D.R. HORTON - GRANDVIEW RESERVE SANITARY SEWER LIFT STATION DESIGN & PERMITTING SERVICES

EL PASO COUNTY
PEYTON, COLORADO
2024

90% CONSTRUCTION DOCUMENTS

CIVIL  
 SITE PLAN

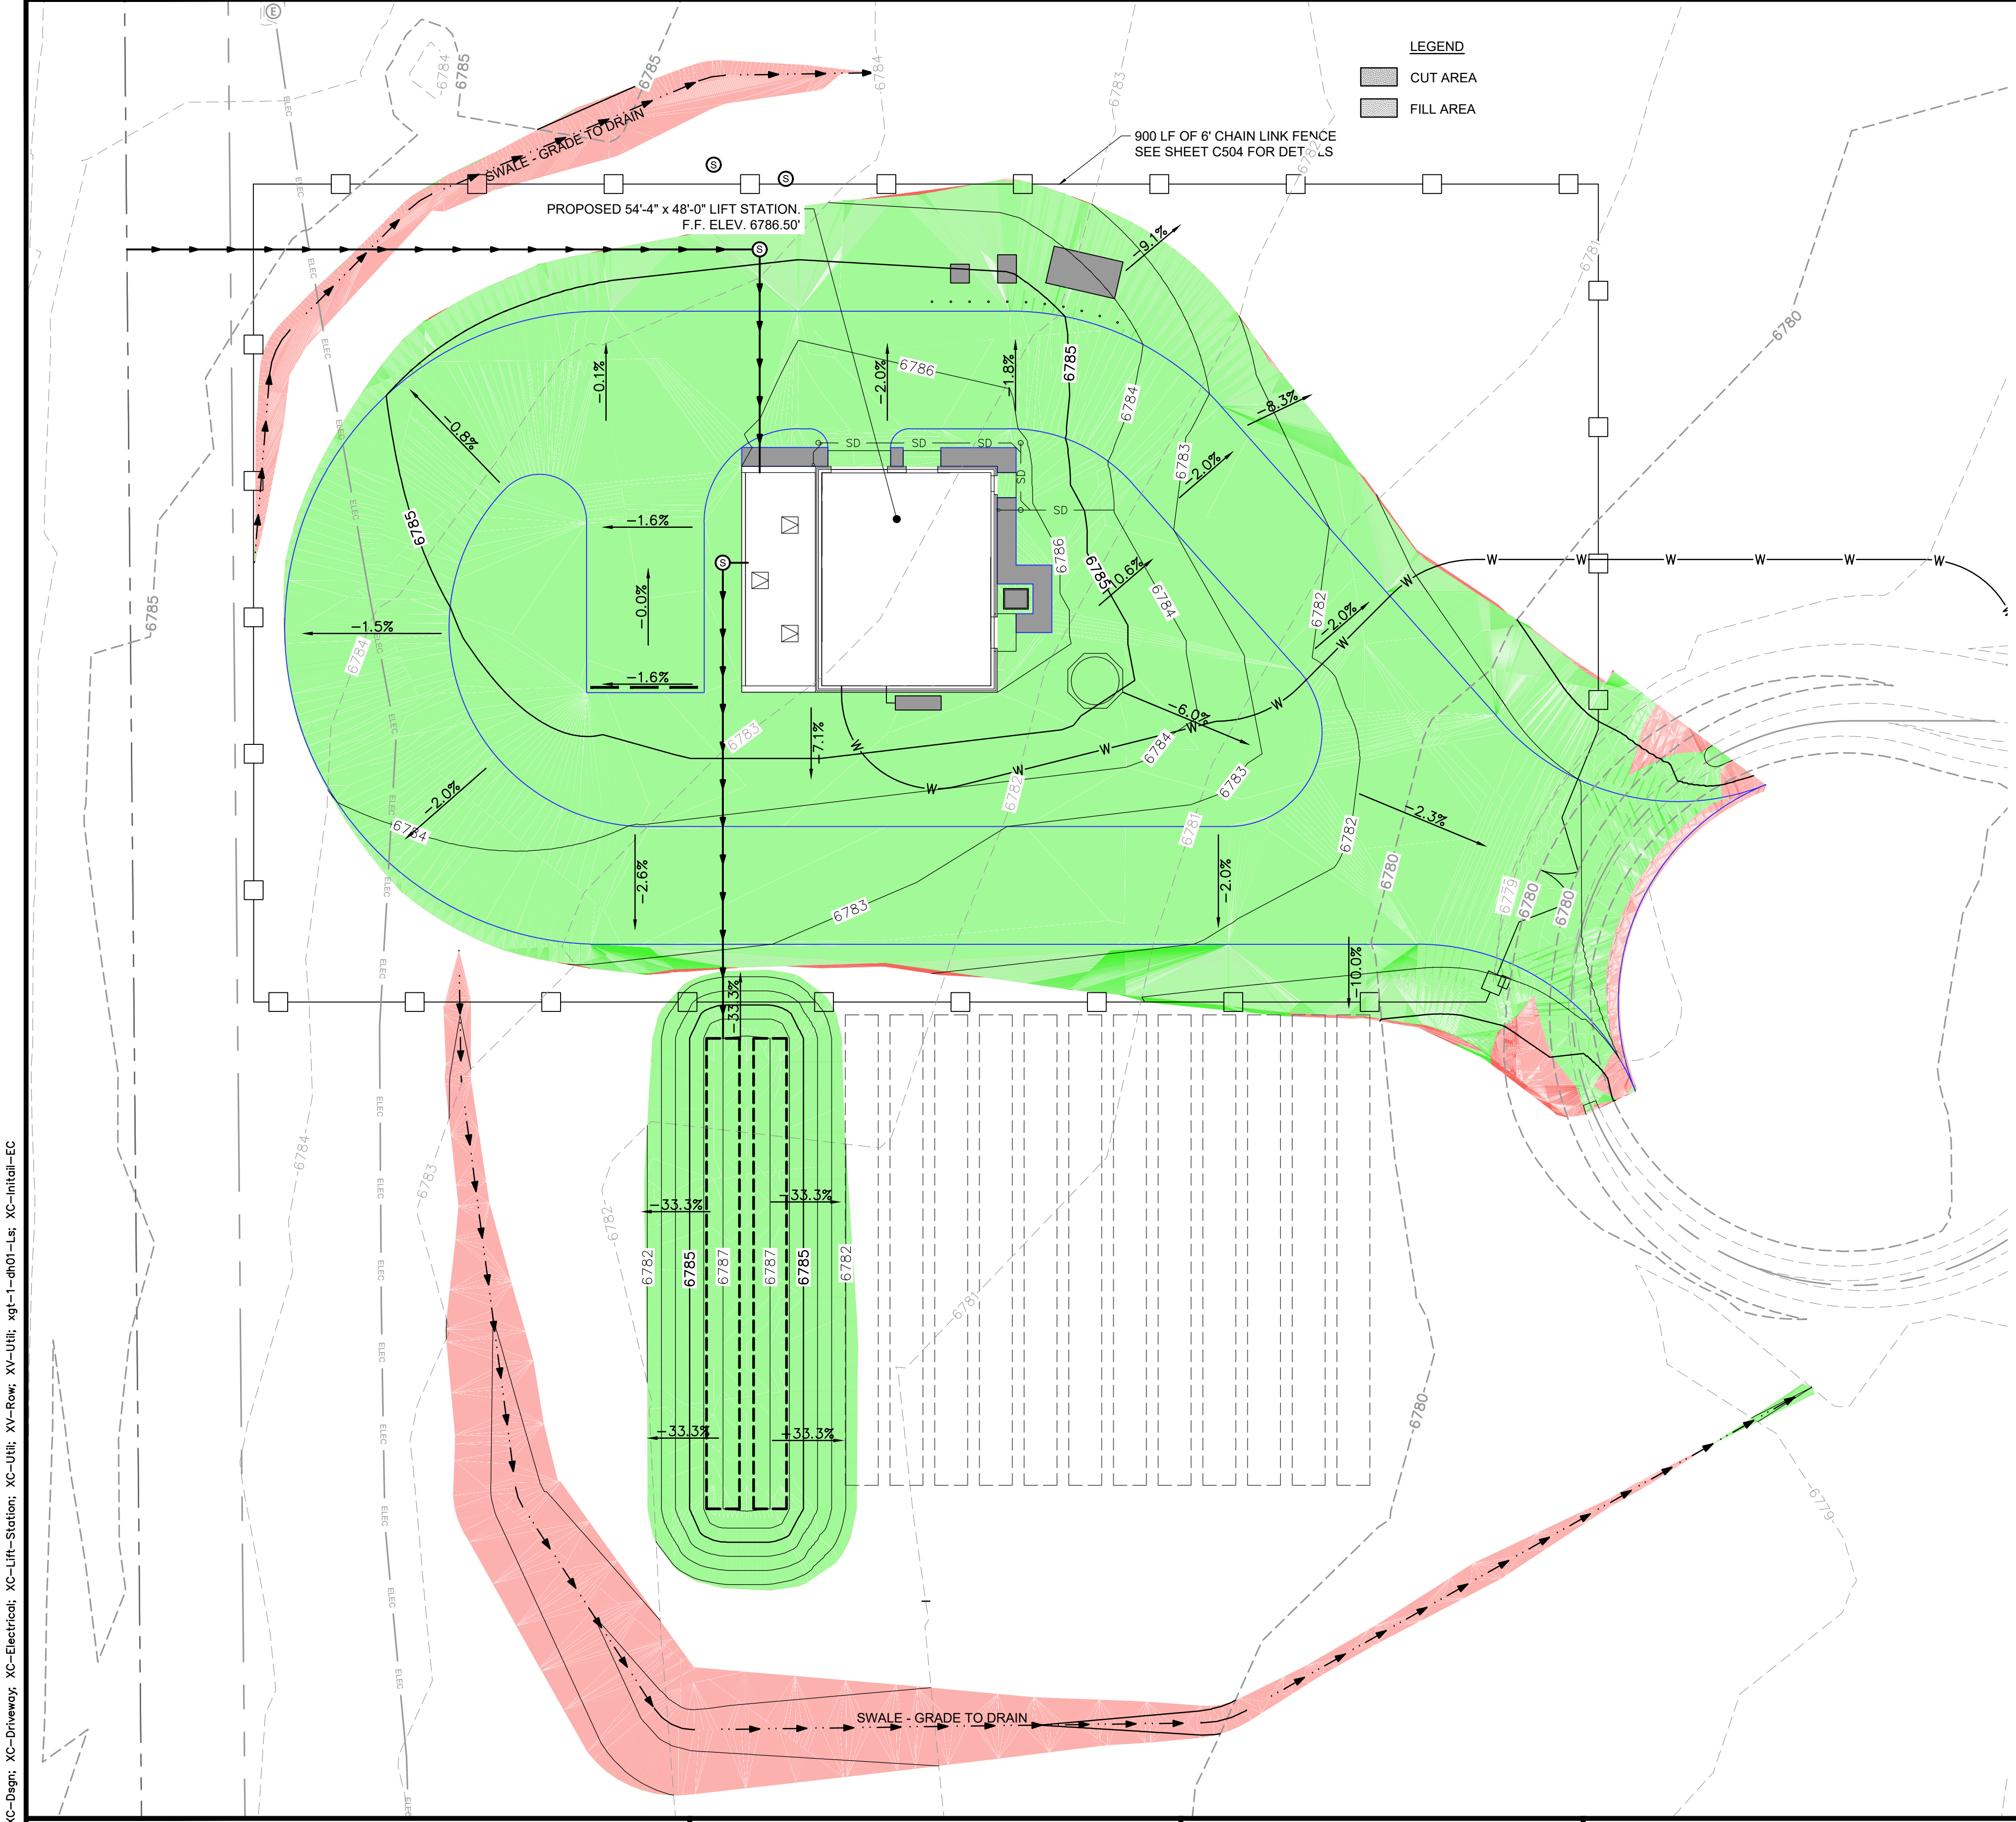
Show and label all existing utility service lines with diameter, material, and either Public and/or private.
 Label as "Gas Distribution Main: AE19M7"
